WEST SUSSEX COUNTY COUNCIL CONSULTATION

TO:	Arun District Council FAO: Simon Davis
FROM:	Highways, WSCC
DATE:	19 th July 2018
LOCATION:	Land West of, Fontwell Avenue, Eastergate, PO20 3RU
SUBJECT:	AL/67/18/PL Continuance of use without compliance with condition 6 imposed under AL/122/17/PL relating to proposed access requirements.
RECOMMENDATION:	☐ Advice ☒ Objection ☐ Modification ☐ No Objection ☐ More Information ☐ Refusal
S106 CONTRIBUTION TOTAL:	£N/A

PROPOSED SITE PLAN 1:500

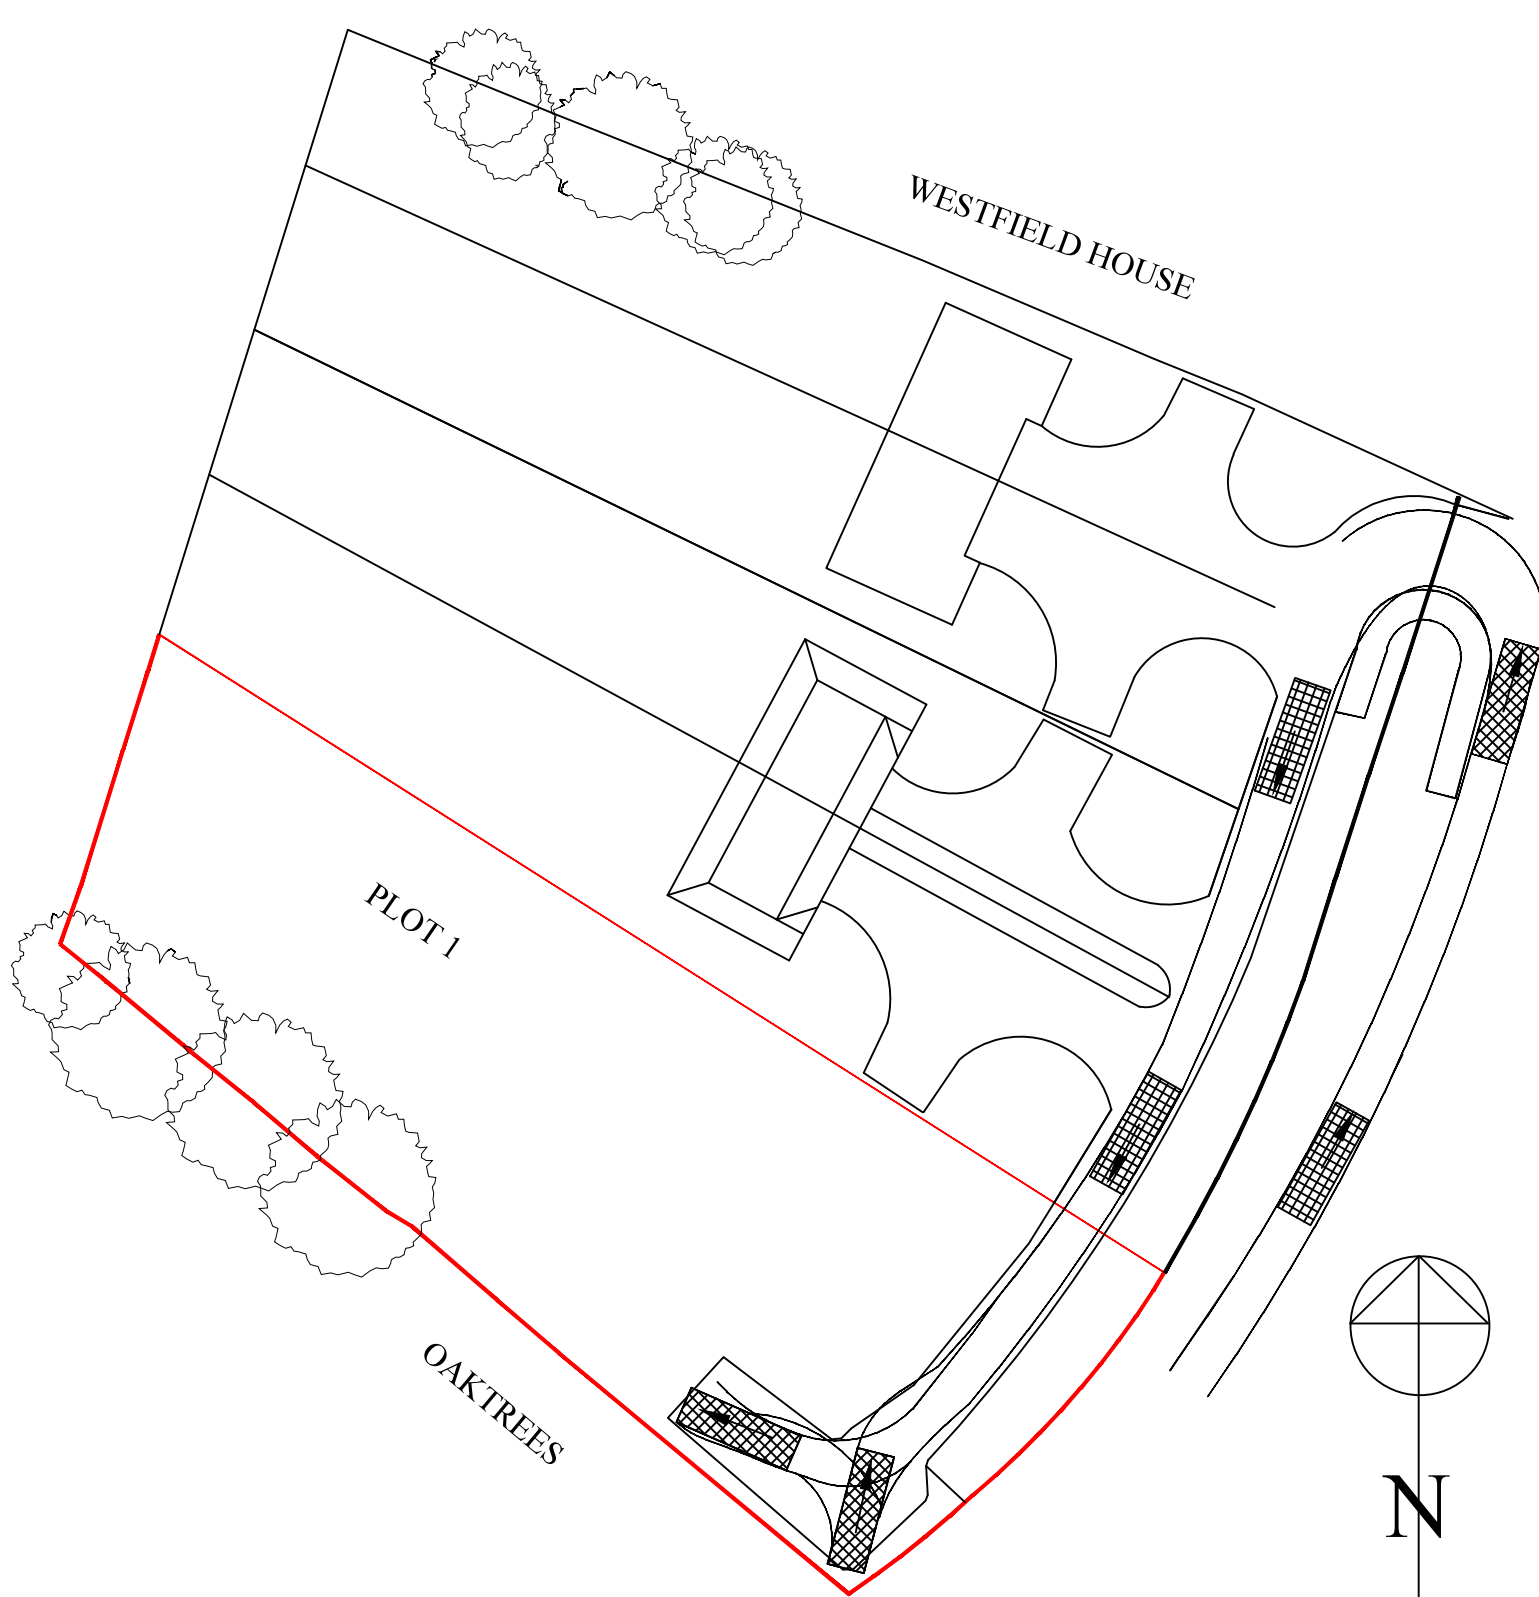
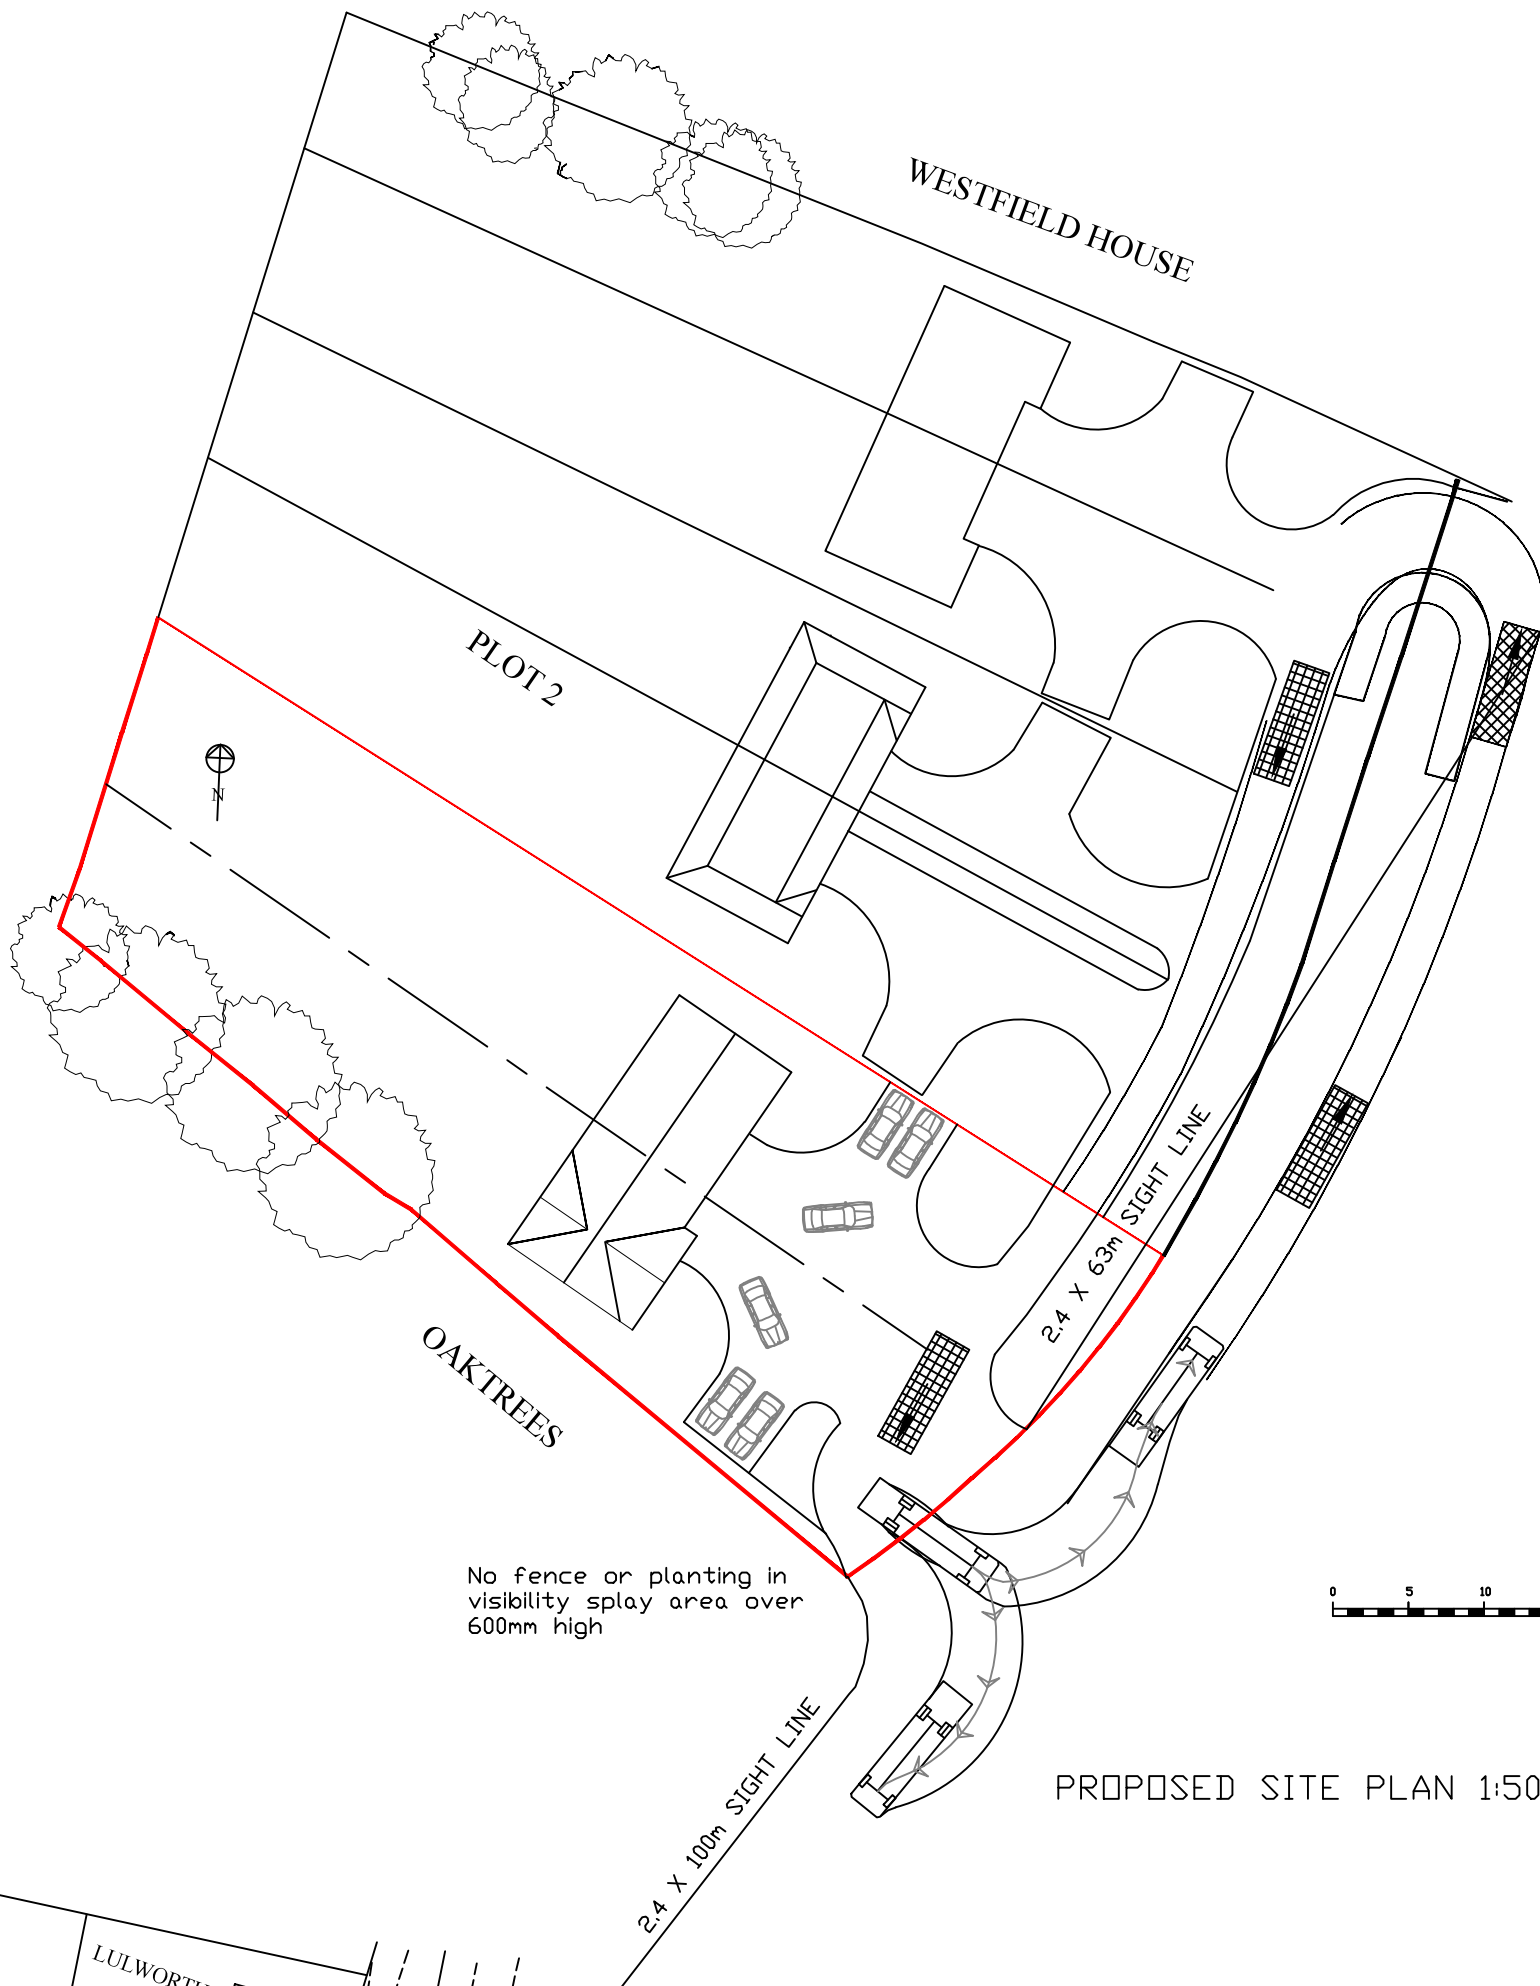
Currently, live application AL/136/17 seeks splitting of furthest south plot to provide 2 x semi detached houses and new second access to A29. Approval of this would result in a total of 6 x dwellings at the site and omission of the previously approved turning head in favour of an in/out dual access point arrangement.

Until such time as the proposals under AL/136/17 have been demonstrated as 'safe and suitable' in line with paragraph 32 of the National Planning Policy Framework, the LHA are not in a position to support the non-compliance of condition application.
